# GEC V\_4.pdf Markup Summary

**Subject:**  
**Page Index:** 3  
**Date:** 2/10/2021 5:55:29 PM  
**Author:** dsdrice  
**Color:** ■  
**Layer:**  
**Space:**  
**Page Label:** [3] 1 21187-01EC1 - EC1

EC03

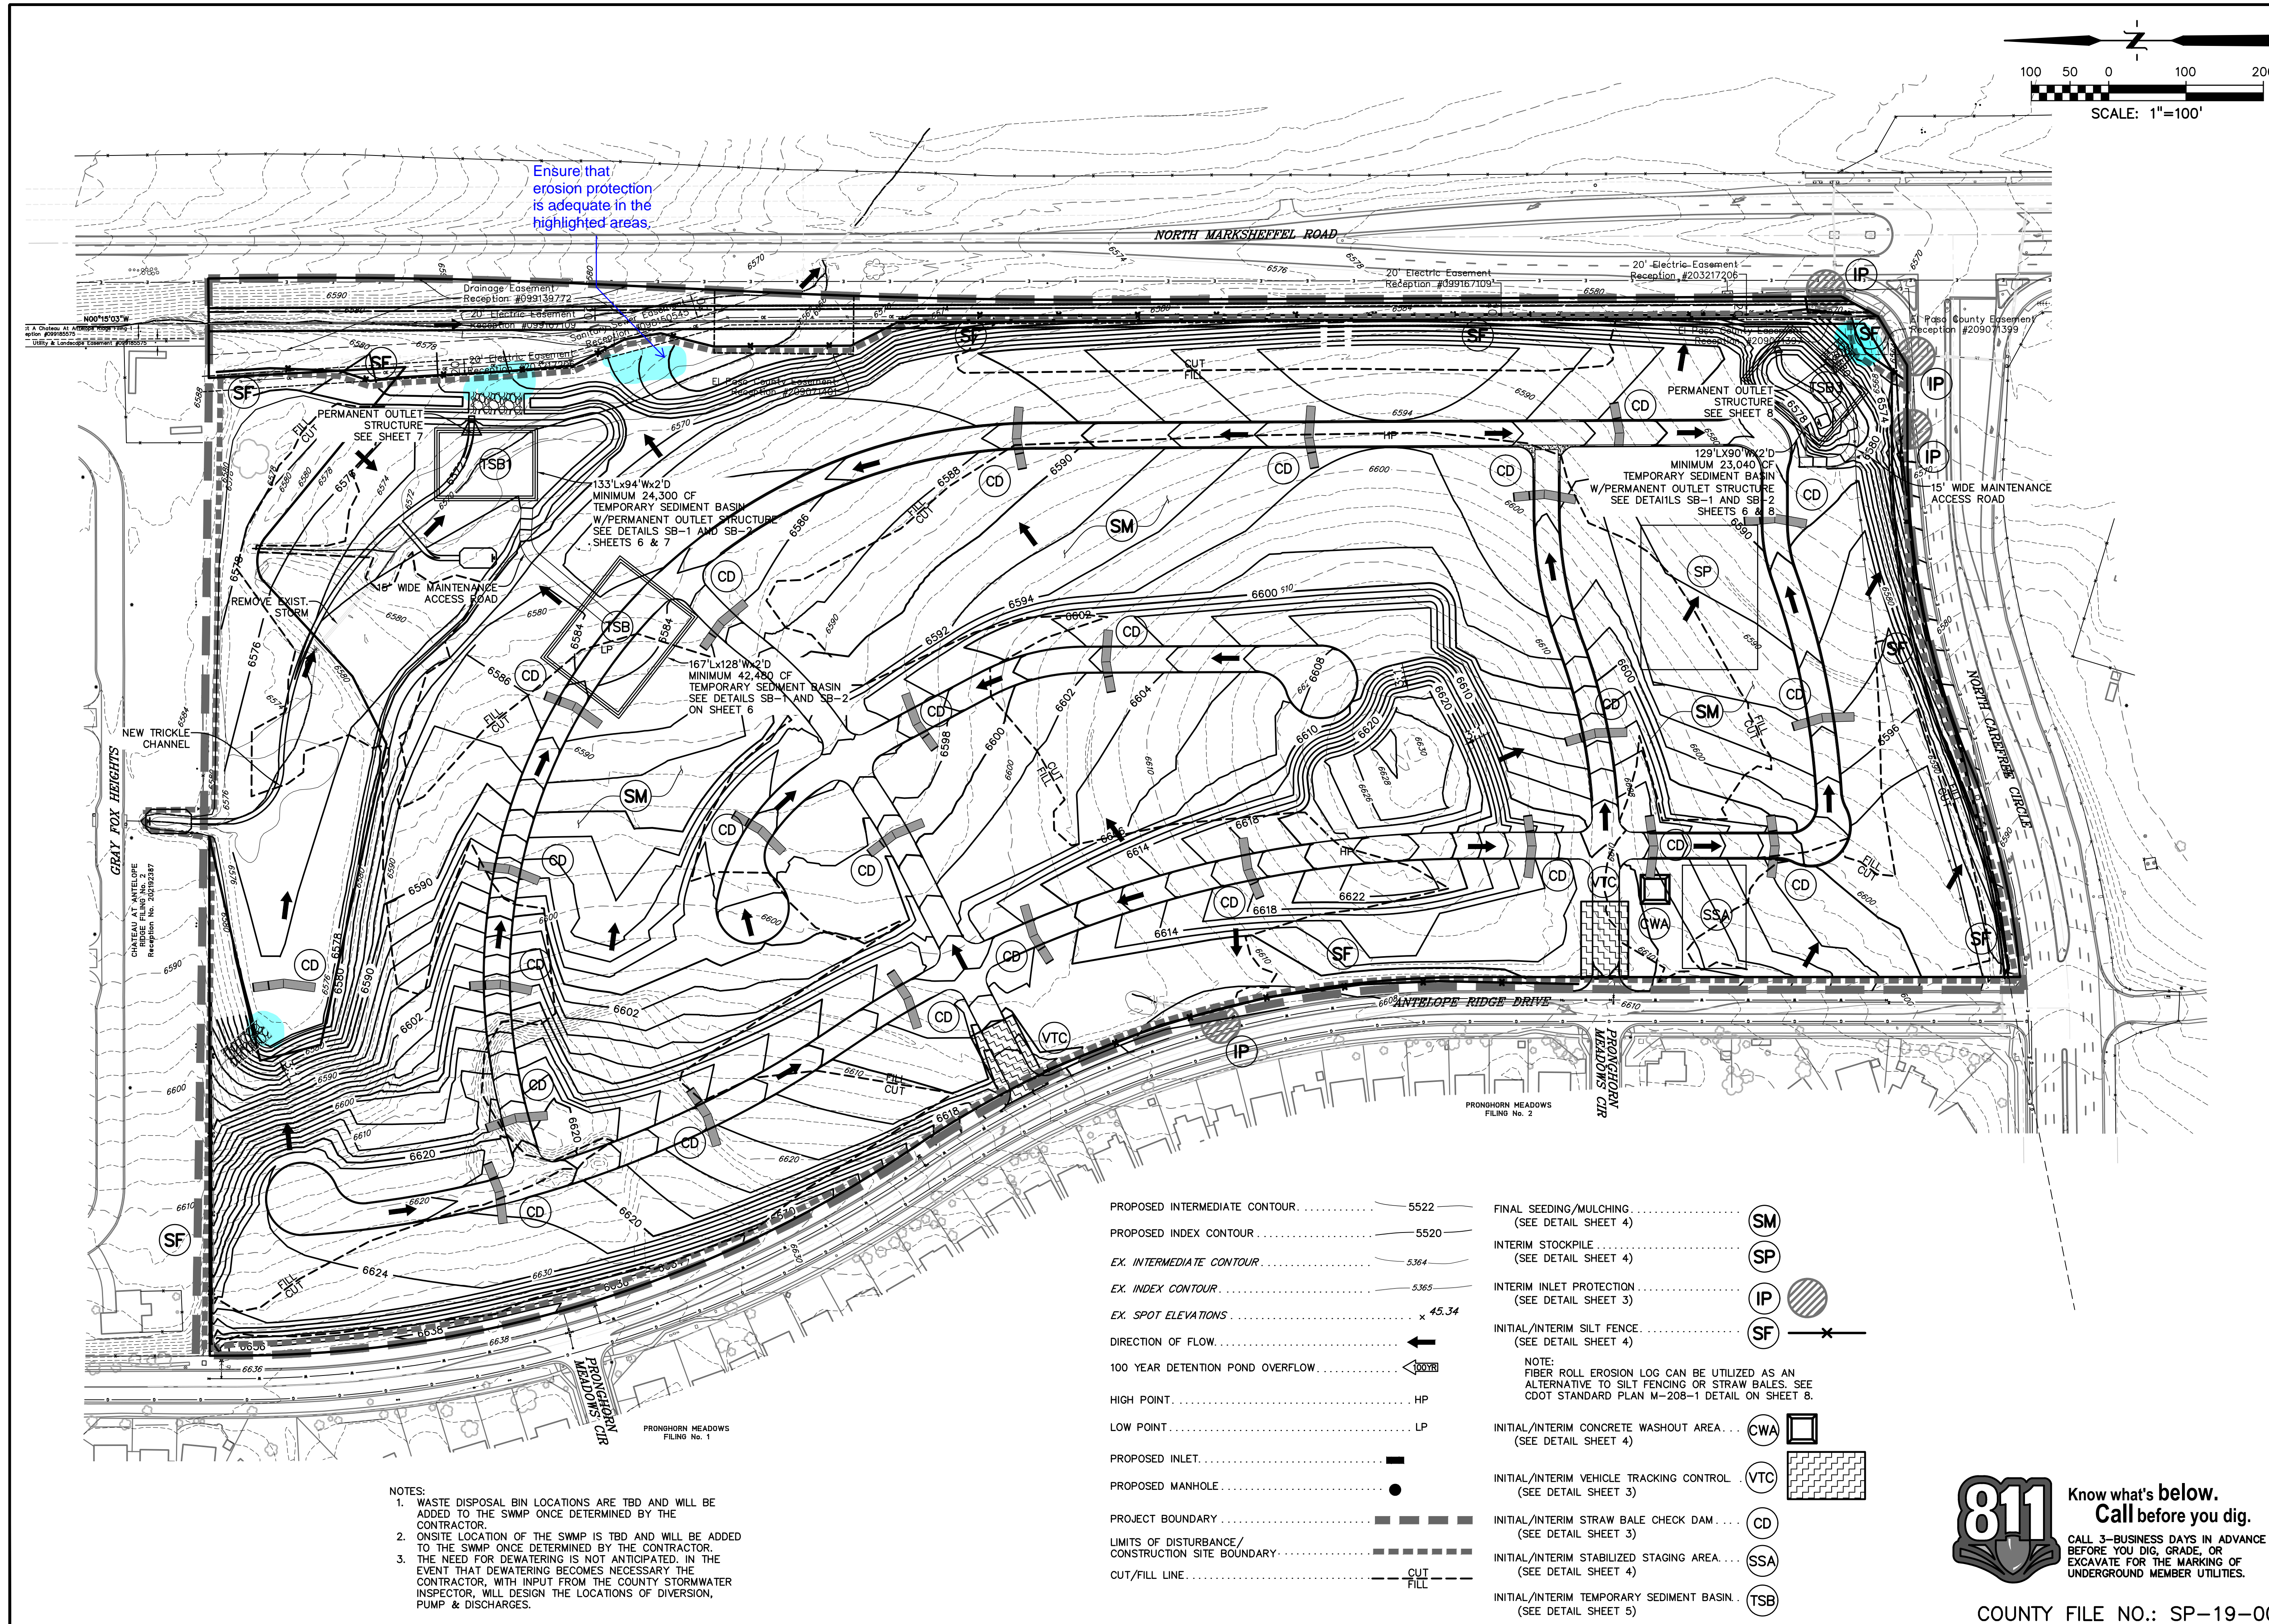
Ensure that erosion protection is adequate in the highlighted areas.
